Austen Quarry Stage 2 Extension Project (MOD 1 - SSD 6084)

Response to Submissions

June 2018

Figure A 29: Channelised right-turn treatment with a short turn slot [CHR(S)] two-lane rural road

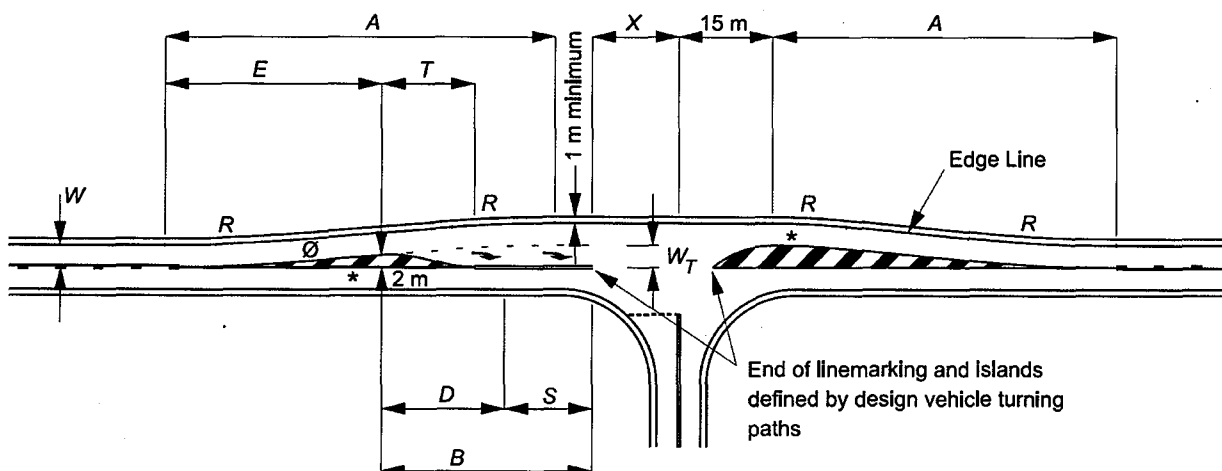
- *Prior to the commencement of Modification 1, a Channelised Right turn lane Short [CHR(s)] is to be provided in Jenolan Caves Road at its intersection with the site access.*

In summary, TTPP considers that the requested upgrade to a Channelised Right turn lane Short (CHR(S)) is not warranted due to the following reasons.

- It is very rare that vehicles transporting Quarry products use Jenolan Caves Road to the south of the Quarry Access Road. The Road Traffic Impact Assessment that accompanied the SoEE assessed the route for product despatch from the Quarry and considered traffic routes towards Sydney and Lithgow. That is, a right turn at the Great Western Highway (95% of traffic) and a left turn at the Great Western Highway (remaining 5% of traffic). Jenolan Caves Road to the south of the Quarry Access Road is mostly used by light vehicles (locally resident staff arriving to and leaving from work) and the occasional heavy vehicle.

- As Jenolan Caves Road to the south of the Quarry is not a principal transport route, the traffic volume turning right onto the Quarry Access Road from Jenolan Caves Road is too low to require a CHR(S). Hy-Tec accepts that on the occasion when heavy vehicles deliver product to destinations requiring them to travel south on Jenolan Caves Road, they will need to safely return to the Quarry, however it is considered that the existing intersection treatment permits safe access to the Quarry and maintains safety for through traffic, i.e. without the need for line marking.

- There have been no reported crashes within 200m of the Quarry Access Road based on the five-year data period between 2012 and 2016 and no complaints from the local community regarding the intersection.

- TTPP also notes that the requirements for intersection upgrade described in the Austroads Guide (Section C6.3) refer to the requirements for construction of new intersections or where existing intersections are being upgraded. This is not the case for the proposed modifications as the proposed changes to traffic volumes do not warrant an upgrade to this intersection.
